Recommendation Report for Planning Permission for Works or Extension to a Dwelling

REF NO: BR/255/18/HH

LOCATION: 30 Mansfield Road
Bognor Regis
PO22 9EY

PROPOSAL: New roof with first floor accommodation, dormer to side elevation, porch to side elevation & rear two storey extension (resubmission following BR/69/18/HH).

PROPOSED ROOF PLAN

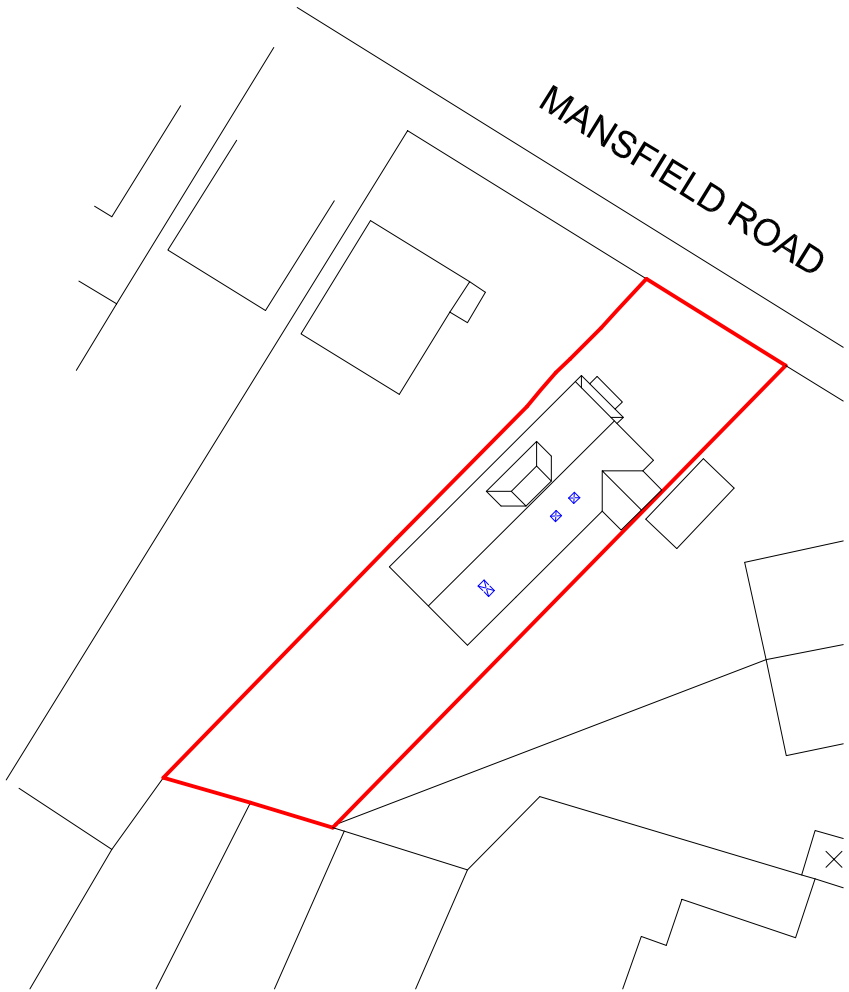
The alteration to the roof from a flat hipped to a gable end will increase the depth and overall roofline of the dwelling by 4.75m to the rear. This will increase the volume of the roof area ultimately increasing the area of the first floor accommodation. The height will match the ridge line of the host dwelling at 6.75m. This will lead to an increase of approximately 4m in height to the rear the dwelling.

PROPOSED ELEVATIONS

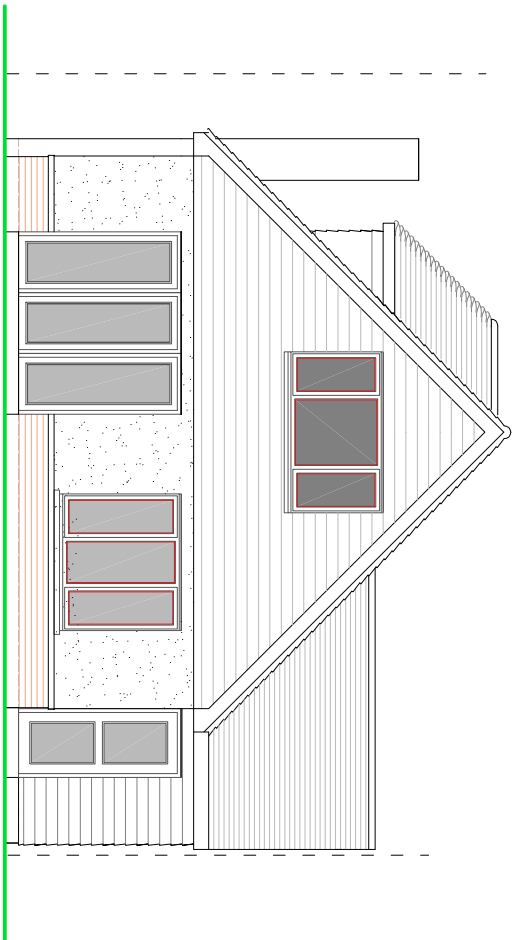
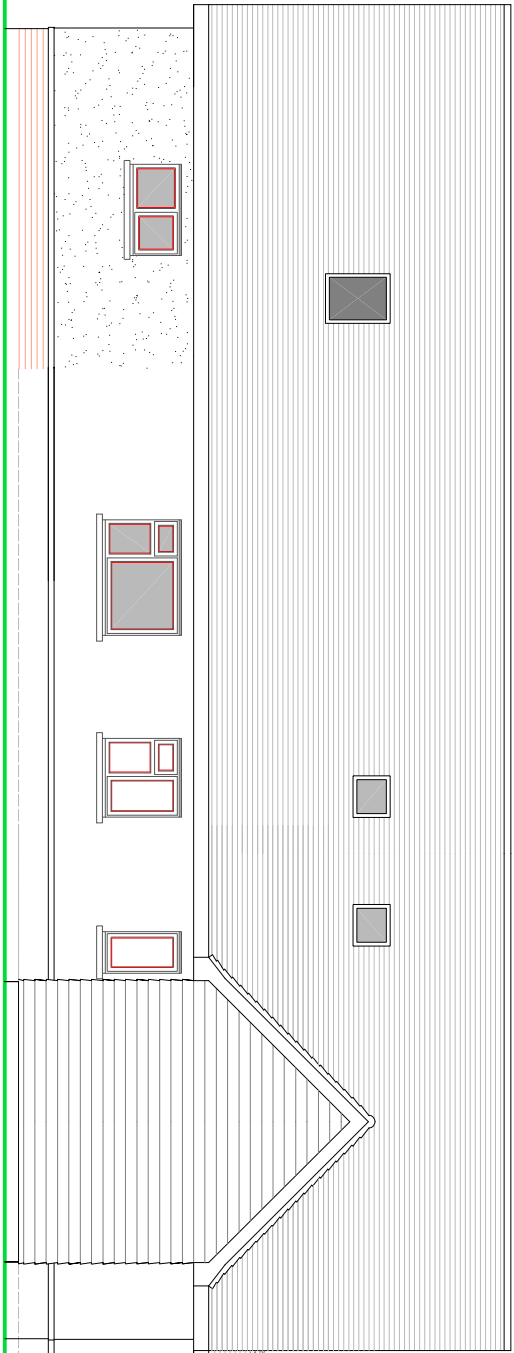
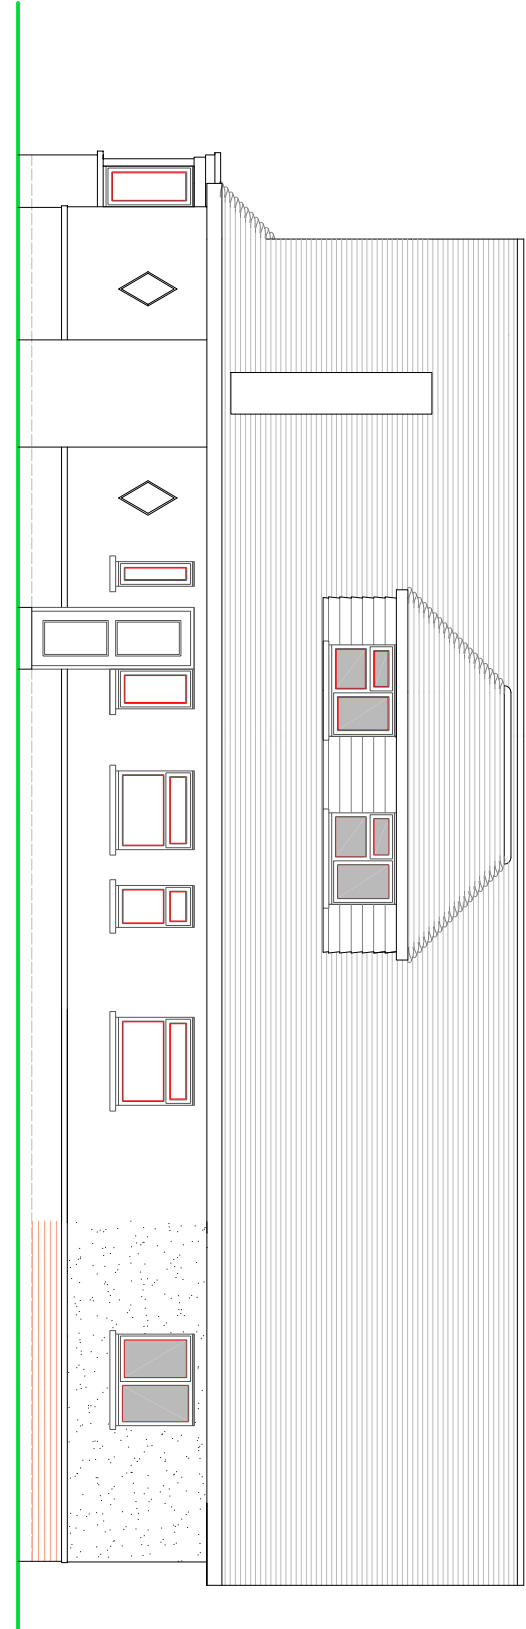
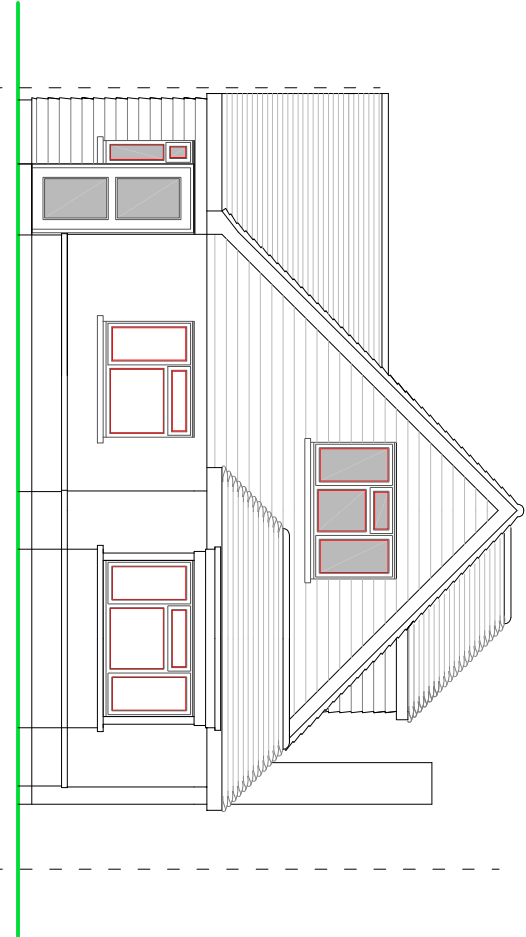
The proposal seeks to construct a gable end to a single storey rear extension on the south east elevation currently with a flat to hipped roof.

The creation of a gable end will result in the addition of significant bulk to the rear of the property and as such this is considered to result in an overbearing impact upon the neighbouring residential amenity specifically to the north at 32 Mansfield Road and to the south west elevation at No 28.Mansfield Road.

The rear of the host dwelling extends beyond that of the rear conservatory of the neighbouring dwelling at No 28. Mansfield Road. As a result of the siting of the host dwelling it is likely to give rise to adverse overshadowing upon this elevation and again to the northern elevation at 32 Mansfield Road. It is noted the proposal is also likely to give rise to a loss of outlook upon properties situated north and north east however this is not considered significant. The application also proposes a velux to the north east side in the additional roof space which is likely to give rise to slight overlooking upon neighbouring amenity to the north east however views are not likely to be significant.

It is considered that by virtue of the proposals increase in height and length in relation to neighbouring dwellings, the proposed development would be overly dominating and therefore significantly harmful upon the neighbouring properties. The overall increase in bulk and scale to the rear will result in a significant increase in overbearing and overshadowing which will give rise to a detrimental impact upon the neighbouring amenity and is unacceptable when seen in context with surrounding dwellings, the majority of which are hipped roofed bungalows. Resultantly the proposal is in conflict with DDM1 (3) and DDM4 (c) of the Arun Local Plan.

- 1 The proposed development by virtue of its siting and its increase in bulk and scale is considered to appear unduly dominant and will result in a significant increase in overbearing and overshadowing which will give rise to a detrimental impact to the amenities of the occupiers at No 28 and No 32 Mansfield Road. It would therefore be contrary to policies DDM1 and DDM4 of the Arun Local Plan (2011-2031) .
